Planning &amp; Urban Development Department

CBL: 020 D013001 (020-D-13-14-15-32)  
Located At: 101-121 Newbury St, and 40-46 Hancock St  
RE: Complaint # 30300/ Partial Lifting of Stop Work Order

3 June 2015  
File No. 42222-000

Subject: Utility Work in Newbury and Federal Streets  
Seaport Lofts Project

PROFILE: HANCOCK ST. AND NEWBURY ST.
OF:
SEAPORT LOFTS
NEWBURY / HANCOCK STREET
PORTLAND, MAINE
FOR:
113 NEWBURY STREET, LLC
38 FAY STREET, SUITE 107B
BOSTON, MA 02116-4520

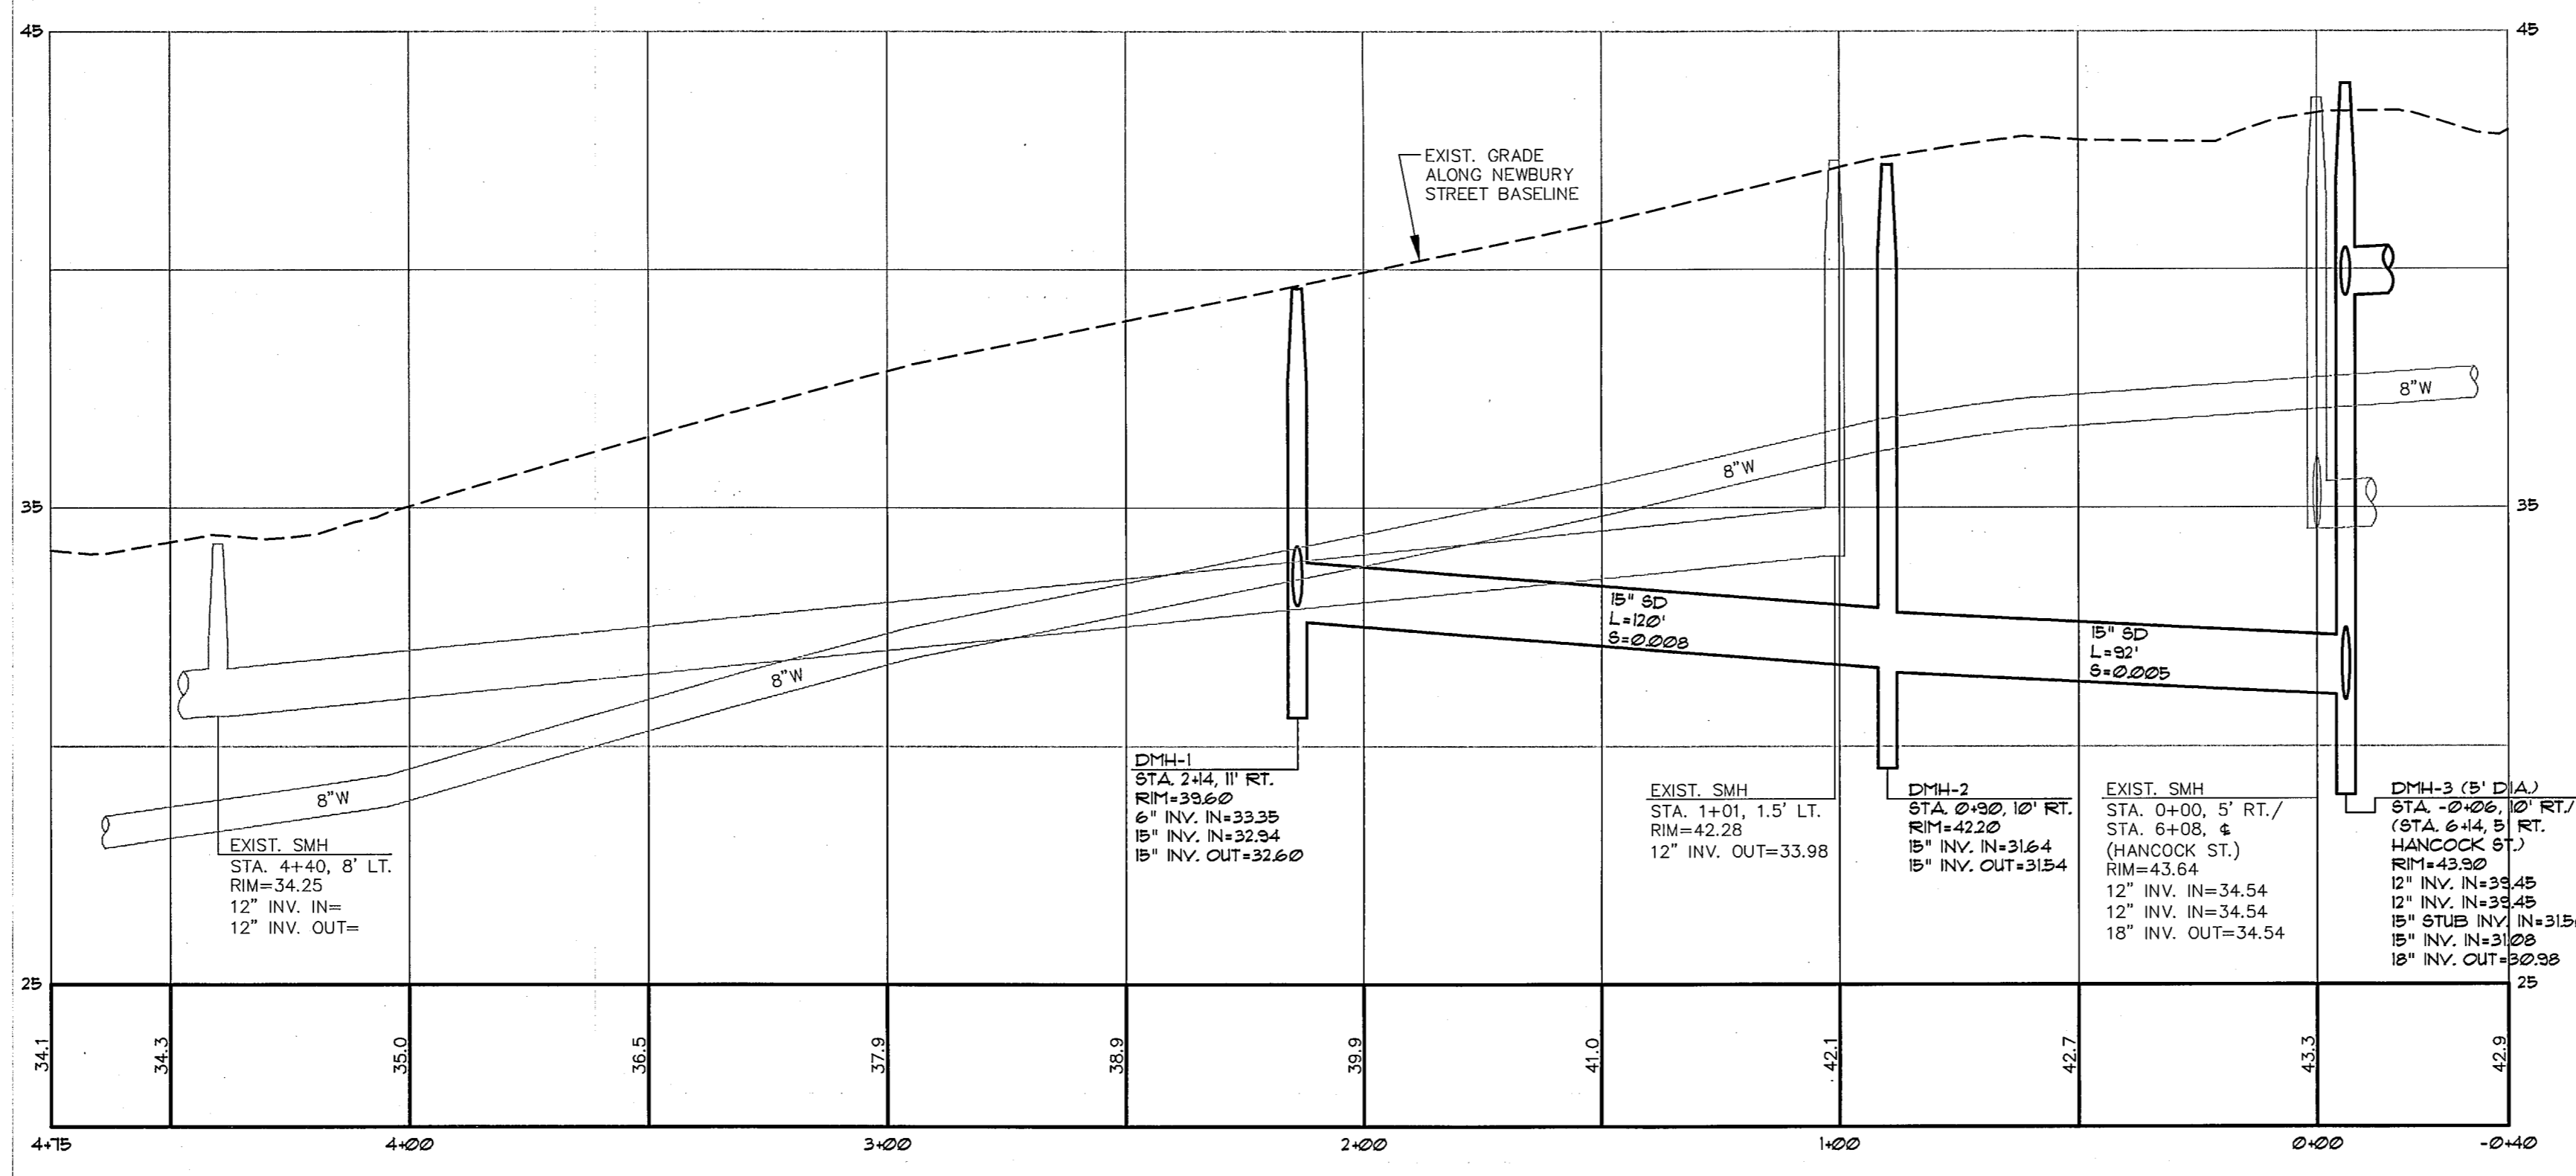
Per discussions with you during our 2 June 2015 site visit, our discussions with RWLR, and our review of the Sebago Technics, Inc. (STI) plans entitled "Grading and Utility Plans, Sheets 4 and 5," it is our understanding that the scope of the new utility work that is proposed is as follows:

- **New Storm Drain Lines:** A new, 18-in. dia., approximately 280-ft long storm drain line will run north from the existing drain manhole at the intersection of Middle and Hancock Street to a new manhole (DMH) DMH-3 at the intersection of Hancock and Newbury Street. From DMH-3 a new, 15-in. dia., approximately 220-ft long storm drain line will run west along Newbury Street to new DMH-1 located near the new entrance to the development. From DMH-1 a new, 15-in. dia., approximately 30-ft long storm drain line will run northwest to new catch basin (CB) CB-2 at the southeast corner of the project site. It is our understanding that CB-2 was previously installed just inside the site boundaries. Associated DMH structures will also be installed as part of this work (i.e., DMH-1, DMH-2 and DMH-3). Based on invert in/out information provided on the STI plans, we estimate that the excavation depth needed to install storm drain lines and manholes will range from approximately 7 to 15 ft (relative to existing site grades).

- **New Foundation Drain:** A new, 6-in. dia., 15-ft long foundation drain located will run from the southwest corner of Unit 17 to new DMH-1 in Newbury Street. Based on invert in/out information provided on the STI plans, we estimate that the excavation depth needed to install this drain line will be approximately 8 ft (relative to existing site grades).

- **New Potable Water Line Stubs:** Two new, 4 and 6-in. dia., approximately 35-ft long water line stubs will run from the southeast corner of Unit 15 to the existing 8-in. dia. water line in Newbury Street. We estimate that the excavation depth needed to install the water line stubs will range from approximately 5 to 6 ft (relative to existing site grades).

- New Sanitary Sewer Stub – A new, 6-in. dia., approximately 30-ft long sanitary sewer stub will run from the Entry/Vestibule to the existing 12-in. dia. sanitary sewer line in Newbury Street. Based on invert information provided on the STI plans, we estimate that the excavation depth needed to install the sewer stub will range from approximately 5 to 8 ft (relative to existing site grades).

OFF-SITE DRAINAGE PLAN
 OF: SEAPORT LOFTS
 NEWBURY/HANCOCK STREET
 PORTLAND, MAINE
 FOR: 113 NEWBURY STREET, LLC
 35 FAY STREET, SUITE 107B
 BOSTON, MA 02118-4320

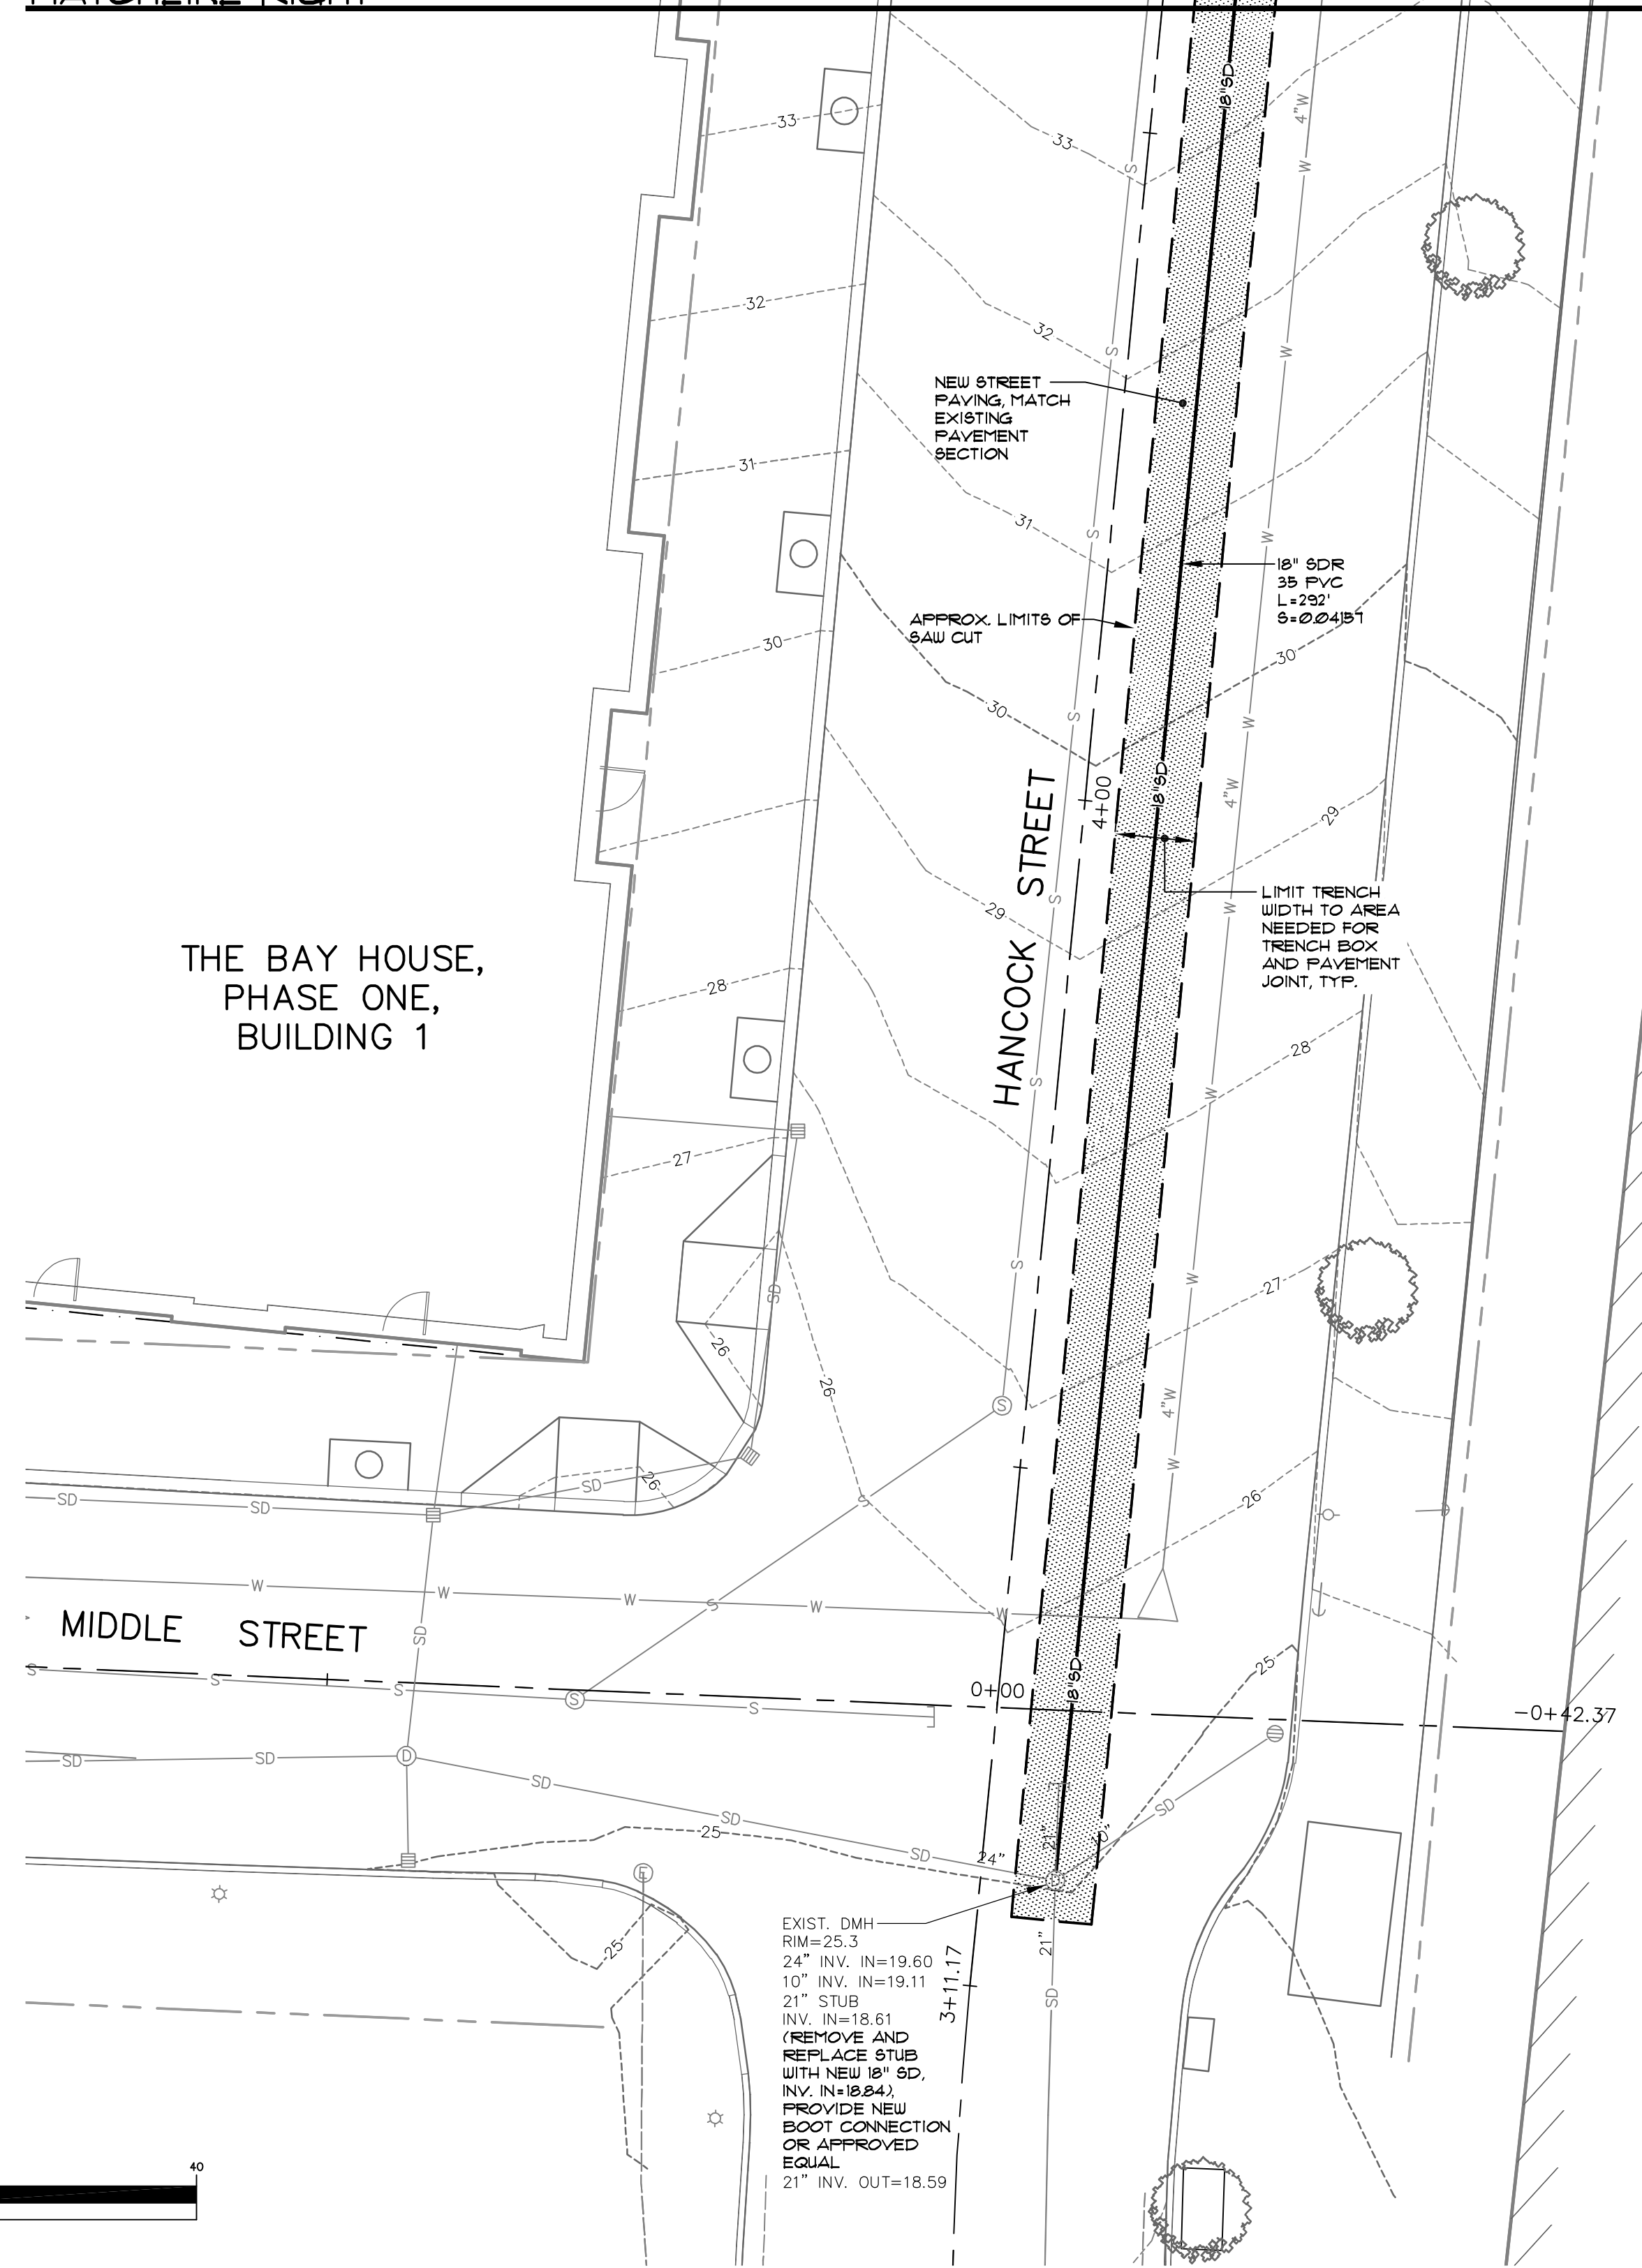
Please refer to the highlighted lengths of utility lines on the attached plans for locations of the infrastructure described above.

Based on the STI plans referenced above, the utility excavations will be 80 ft or more (in plan) from the new retaining walls along the north side of the project site, 100 ft or more from the existing retaining wall adjacent to the blue house at the northeast corner of the site, 105 ft or more from the existing blue house at the northeast corner of the site, and 150 ft or more from the Federal Street Townhouses located north of the site. Based on discussions with you, it is our understanding that the excavations will be supported using trench boxes. It is also our understanding that the trenches will be excavated, the utilities installed, and the trenches backfilled in a sequenced manner such that only short lengths of trench excavations will be open at any one time.

Based on the scope of the utility work, the location of the work relative to the structures on the north side of the site, and the planned means and methods of utility installation, it is our opinion that the installation of the new utility lines in Hancock and Newbury Streets can be safely completed without causing additional movement of the new site retaining wall and the existing adjacent structures north and northeast of the site. As a precaution, we recommend that the established survey points be surveyed prior to, during and after the utility work to confirm that no additional movement has occurred.
